Application Ref: 24/00140/DPP Pre-application Ref: \_\_\_\_\_ Online App

<p><b>UPRN:</b> 000120024987 (If <b>NO</b> UPRN – Admin to contact Technician)</p> <p><b>Site Address:</b> <i>(Leave blank if no UPRN)</i></p> <p>12 GORDON STREET EASTHOUSES DALKEITH EH22 4DS</p>	<p><b>Description of Proposal:</b></p> <p>Erect a single storey to rear of dwellinghouse and a single storey garage extension to side</p>
---	---

This copy has been made by or with the authority of Midlothian Council pursuant to Section 47 of the Designs and Patents Act 1988. Unless that Act provides a relevant exception to copyright, the copy must not be copied without the prior permission of the copyright owner.

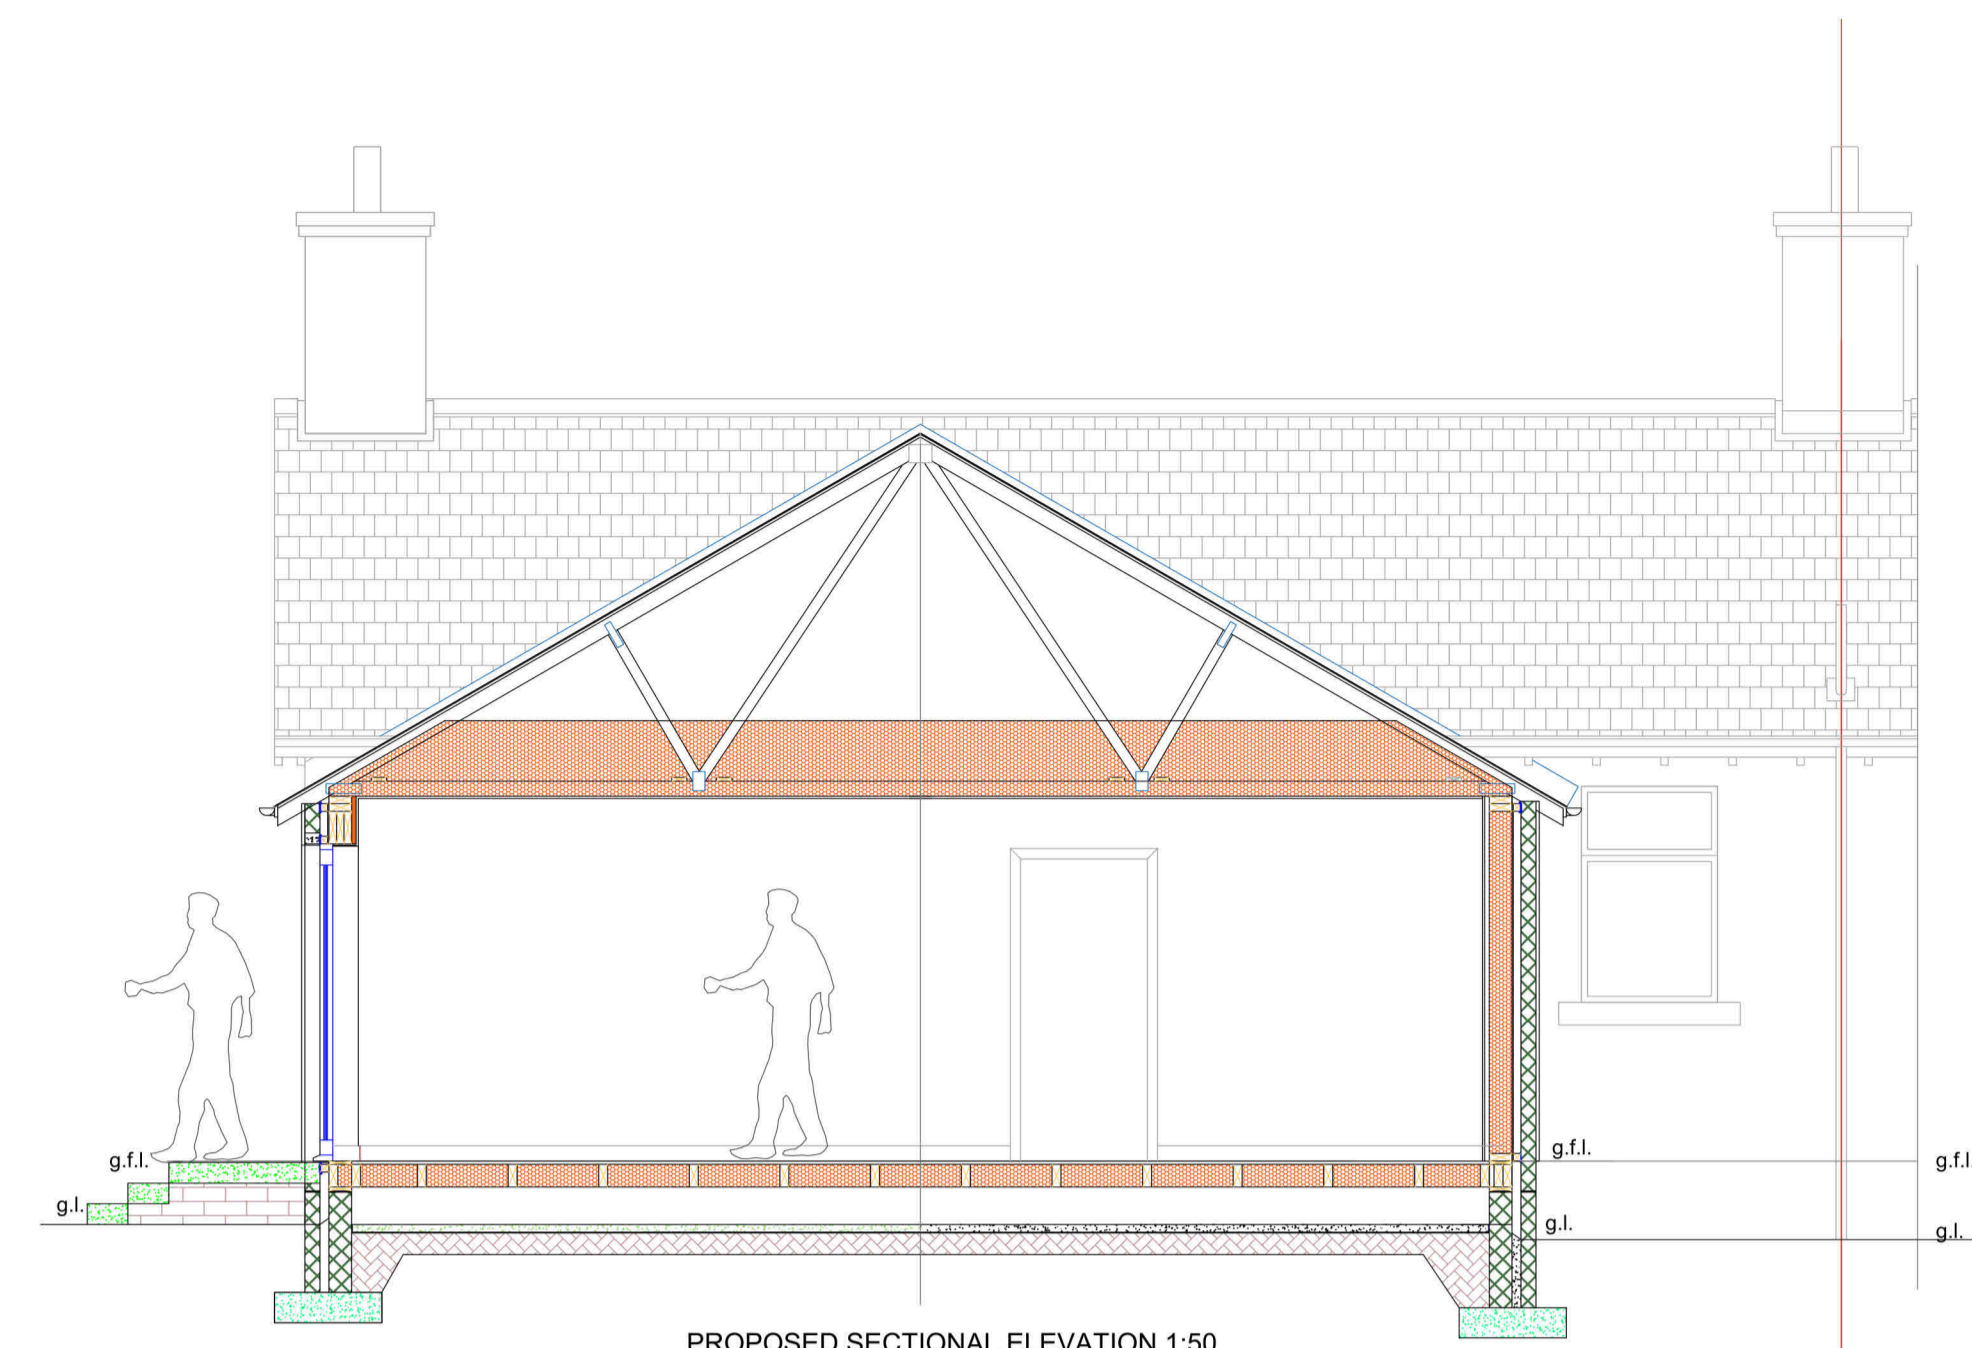
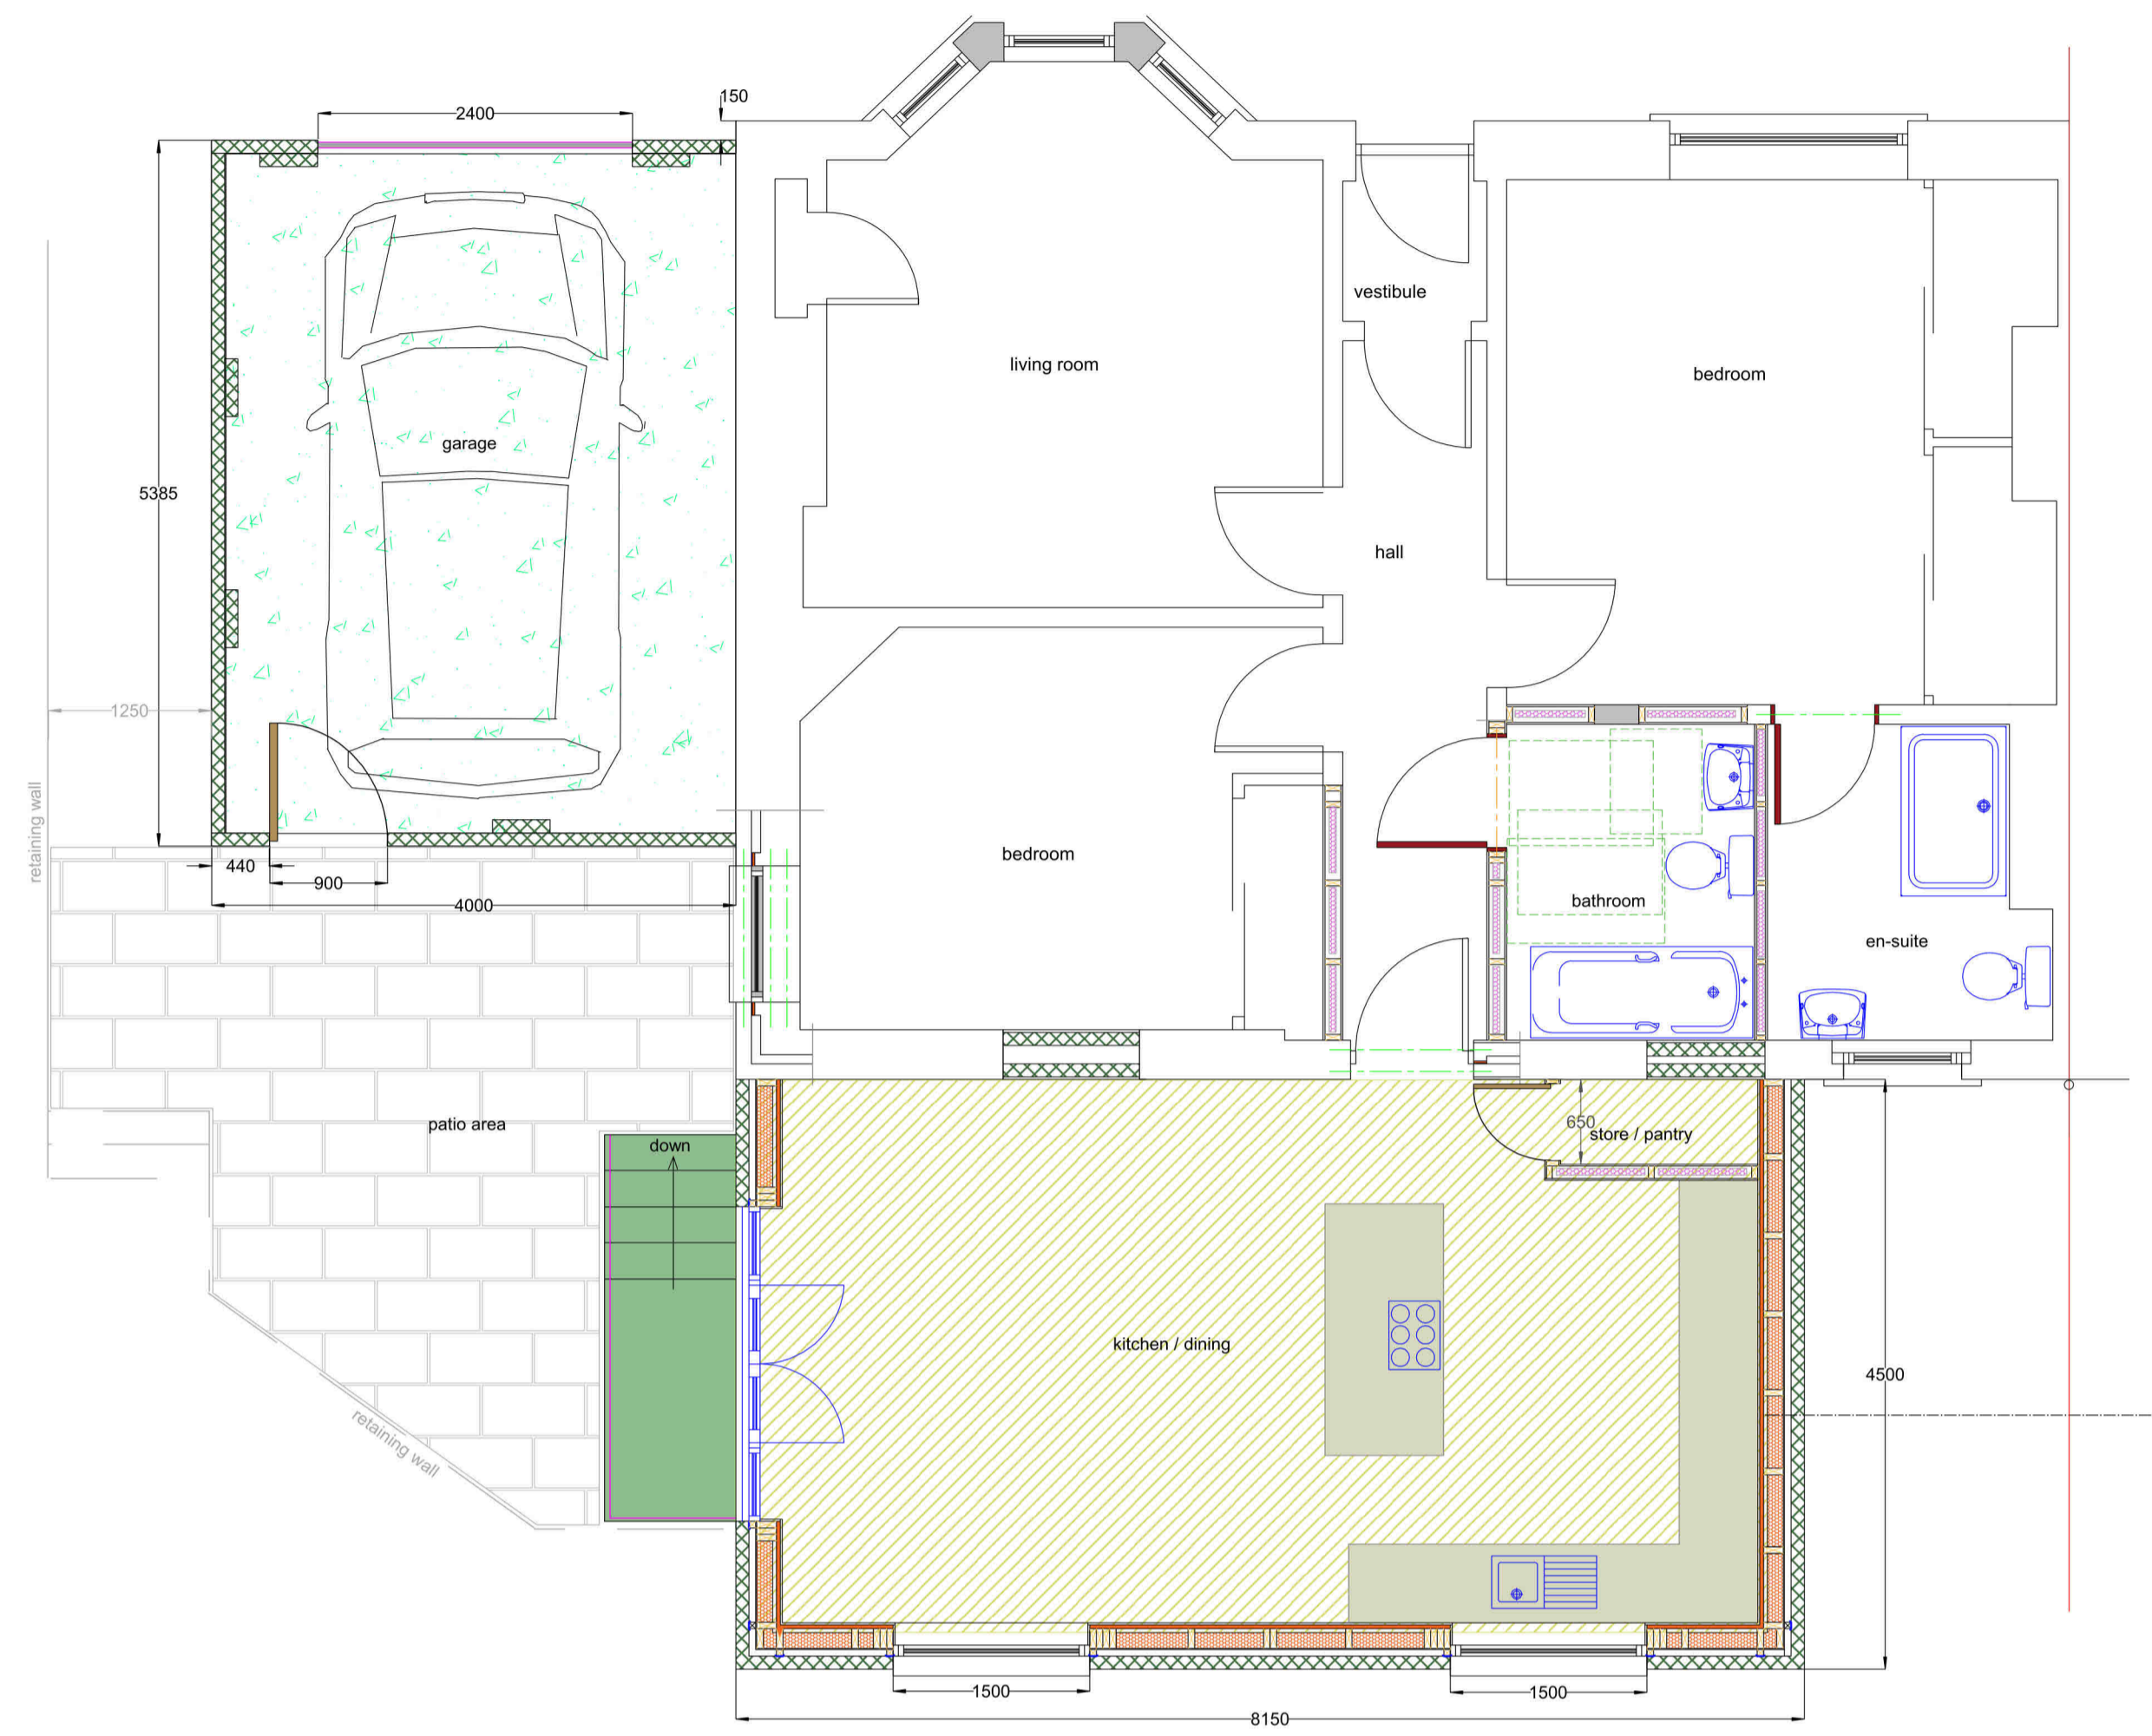
| <input checked="" type="checkbox"/> | <b>Inadequate Plans</b>       | The following additional plans are required: <ul style="list-style-type: none"><li>- Existing and proposed roof plan</li><li>- Existing end west elevation plan</li><li>- Existing chimney not shown on proposed west elevation plan however it appears that this is to be retained. Please could you check this and confirm if correct.</li></ul> |

- For ease it would be beneficial if all existing and proposed plans were shown on separate drawing sheets. Currently the proposed front elevation is contained on the drawing sheet with existing elevations.
